KITTITAS COUNTY

MEMORANDUM

TO: All Staff
FROM: Public Works Plan Review Team
DATE: October 5th, 2023
SUBJECT: Public Works Comments: BL-23-00023 M&M Lowe Family LLC

PRELIMINARY ONLY!

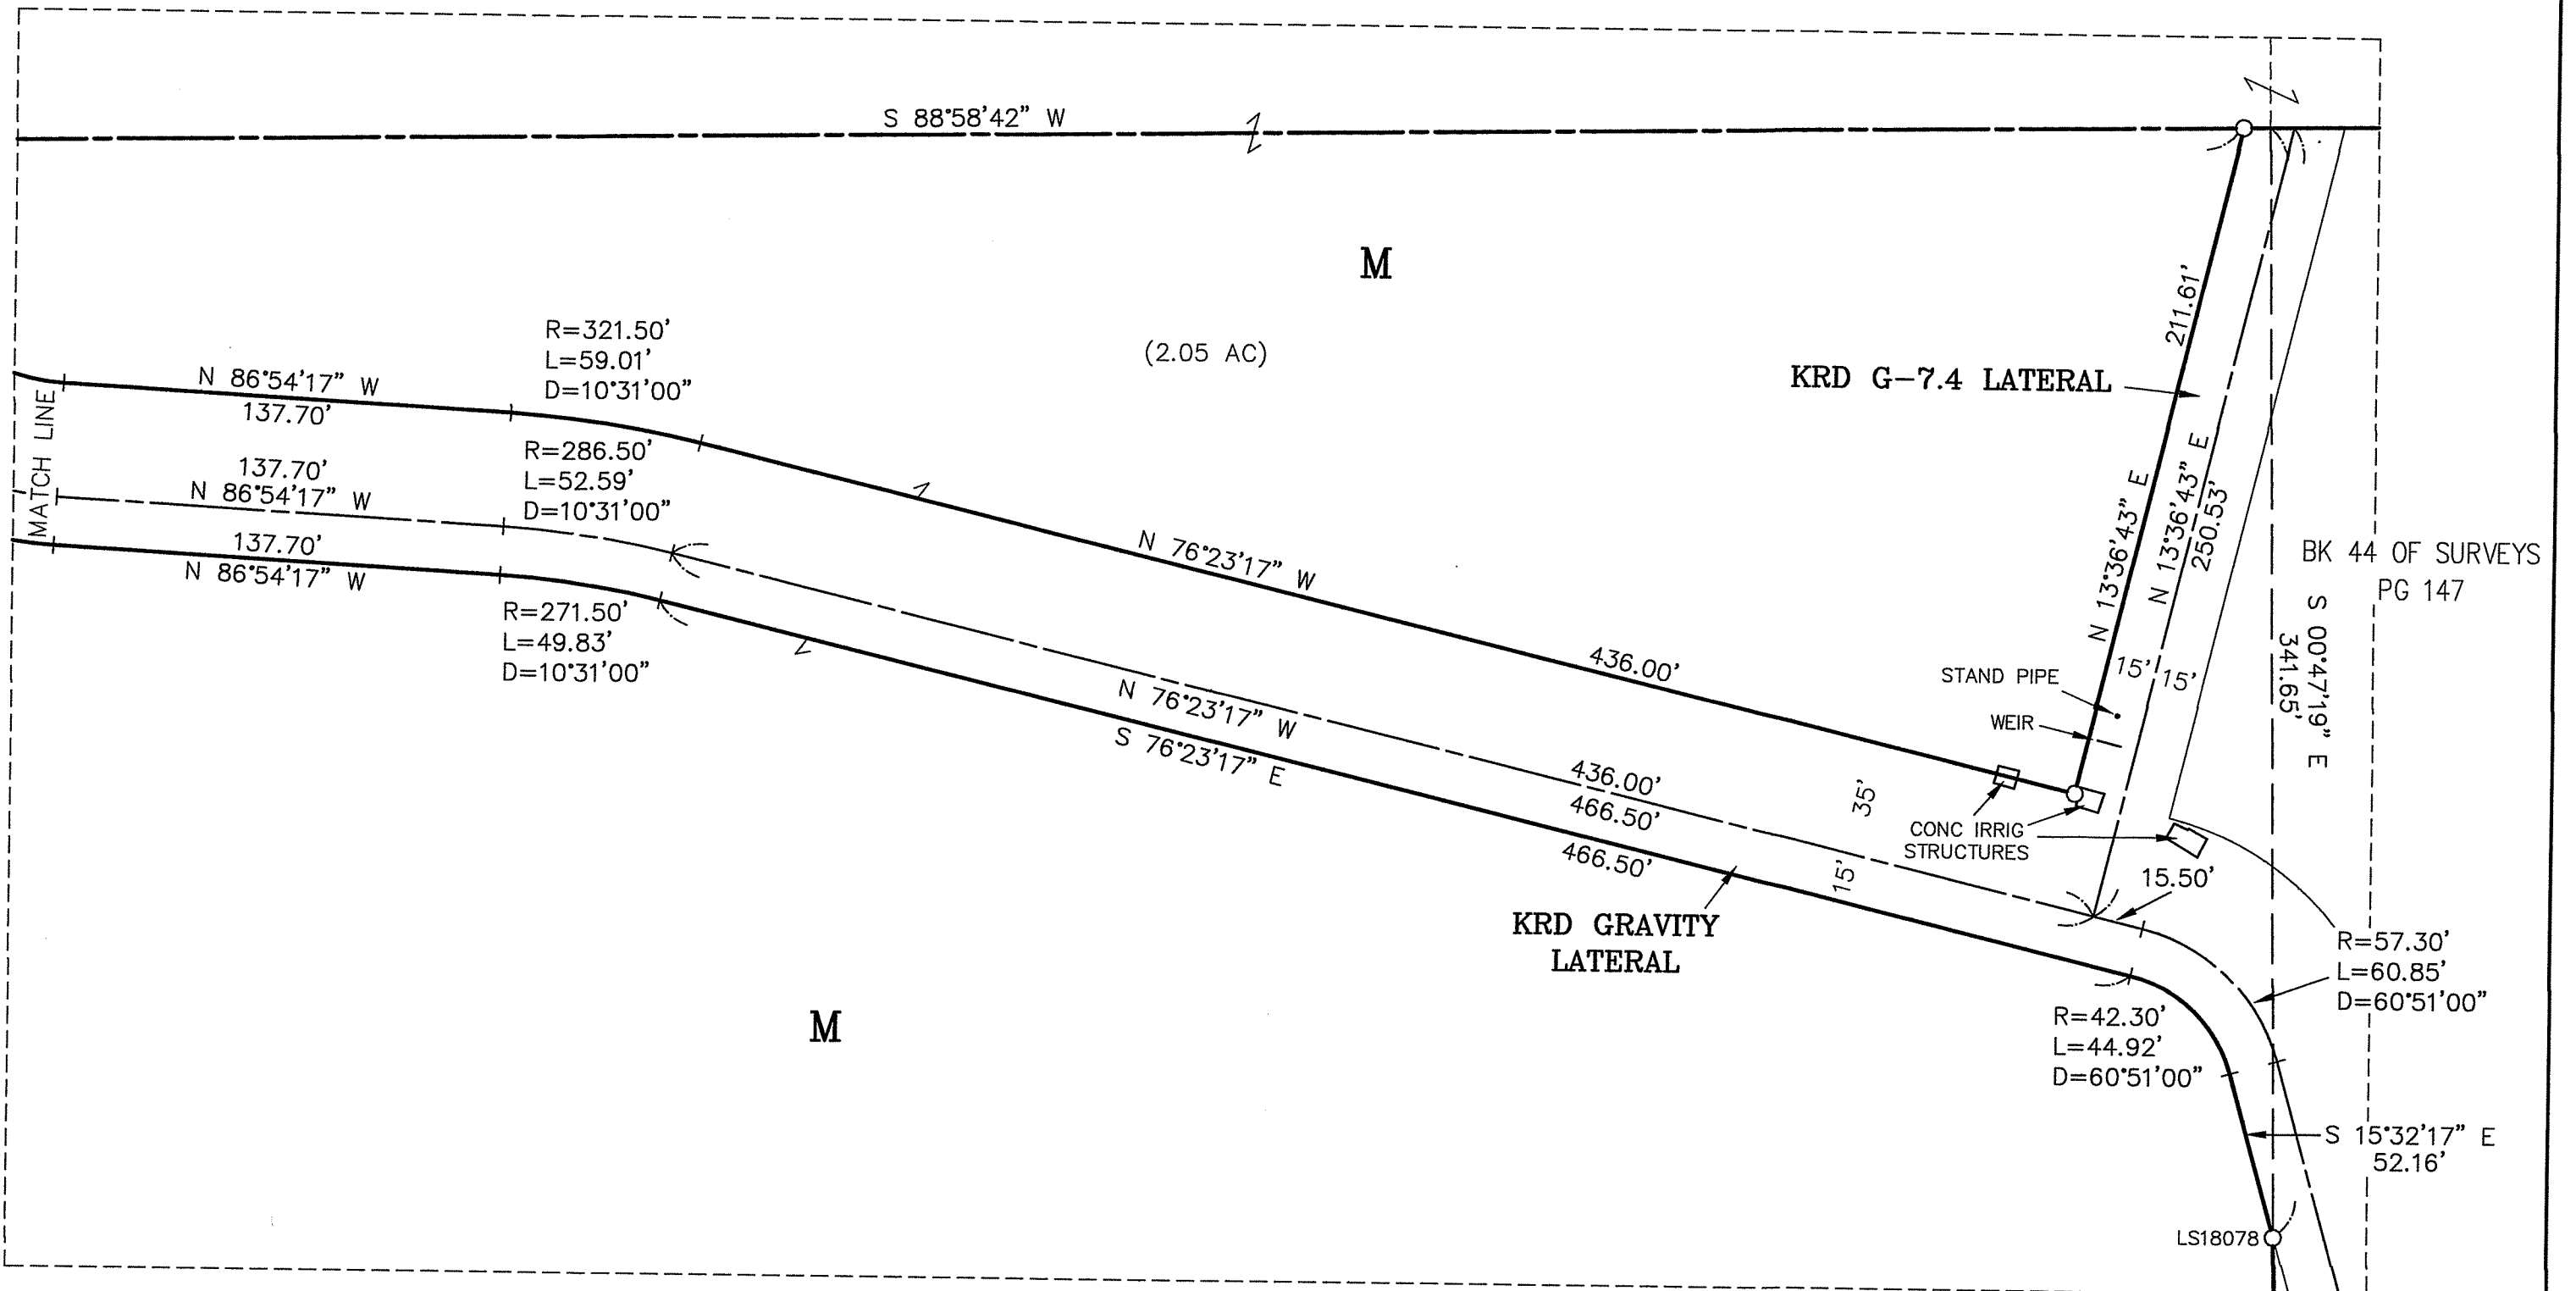
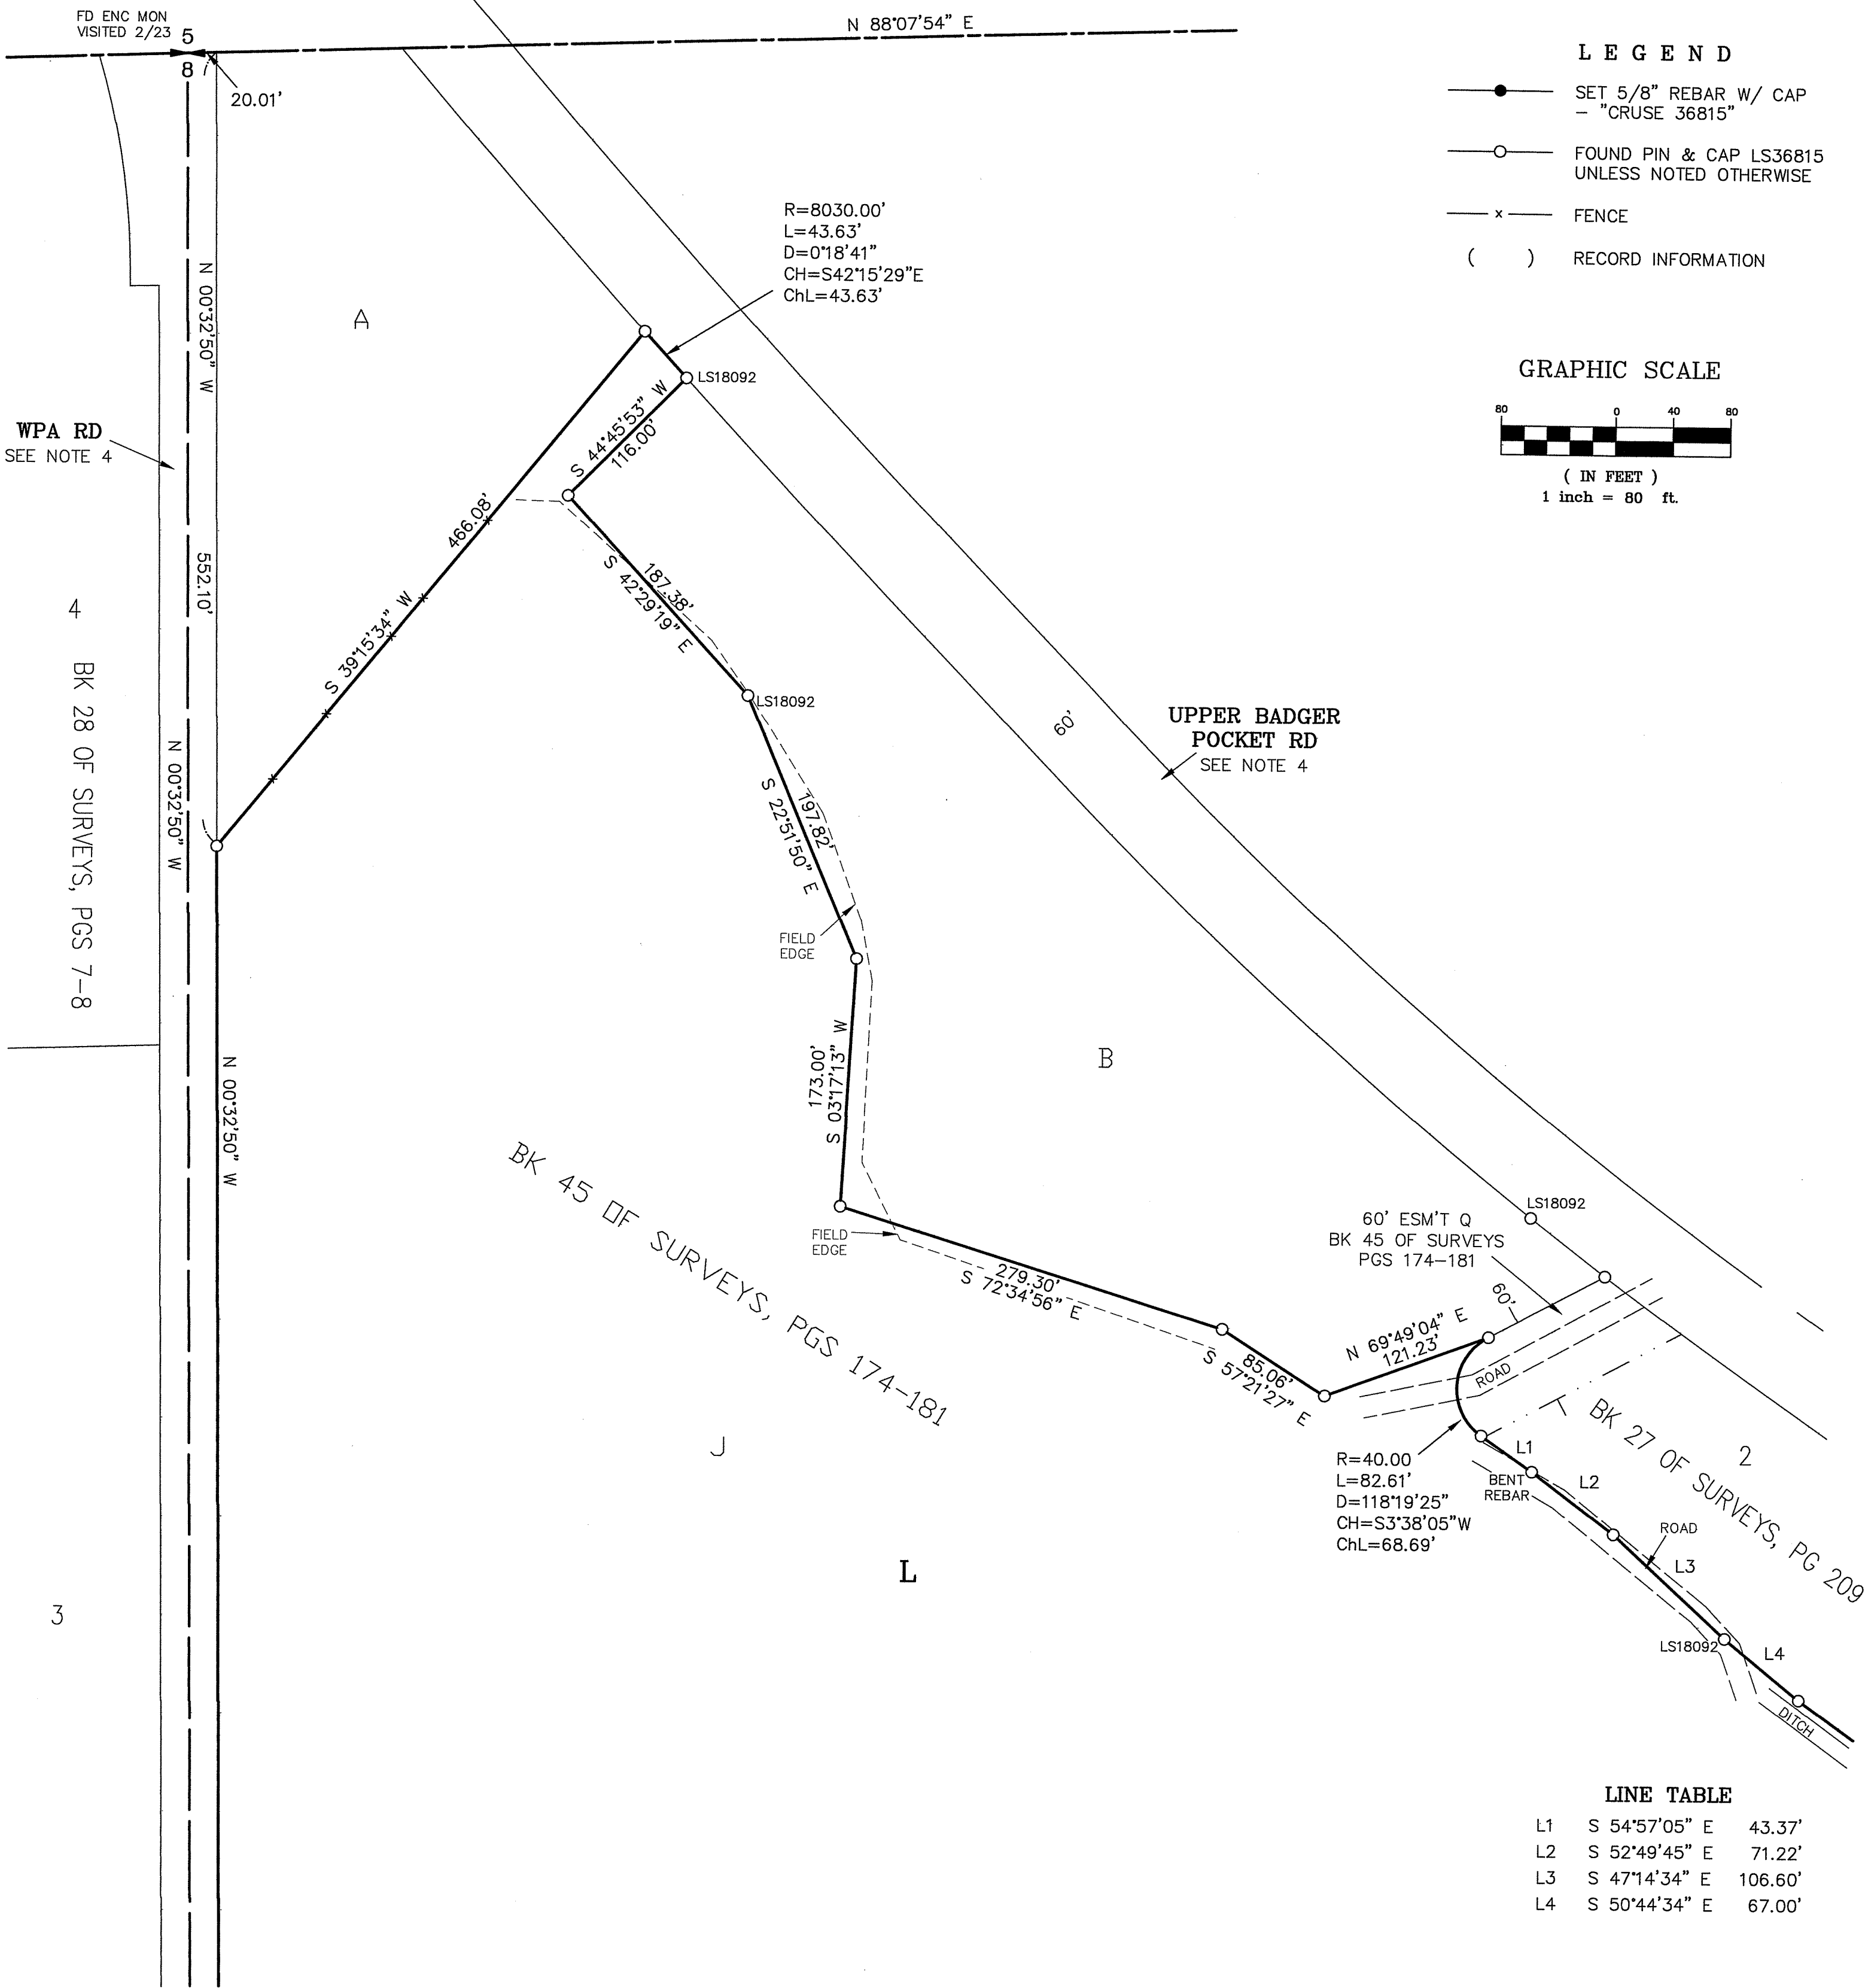
<p>SURVEY</p>	<p>As the application does not contain a survey map, survey reviewed is reserved until final submittal. (JT)</p> <p>UPDATE 11/21/2023</p> <ol style="list-style-type: none"> 1. Please include the R/W width, ownership and surfacing for all roadways. 2. Please show the total distance for the S line of SE1/4 of Section 8. 3. On Sheet 5, Please include the distance along the section line for the E' most portion of Parcel M, in Section 17 N of the lateral (780.56 per the closure rept). 4. Please remove the thin grey line that runs through the legend on Sheet 5. (this may be a result of printing or scanning) 5. (this may be a result of printing or scanning)
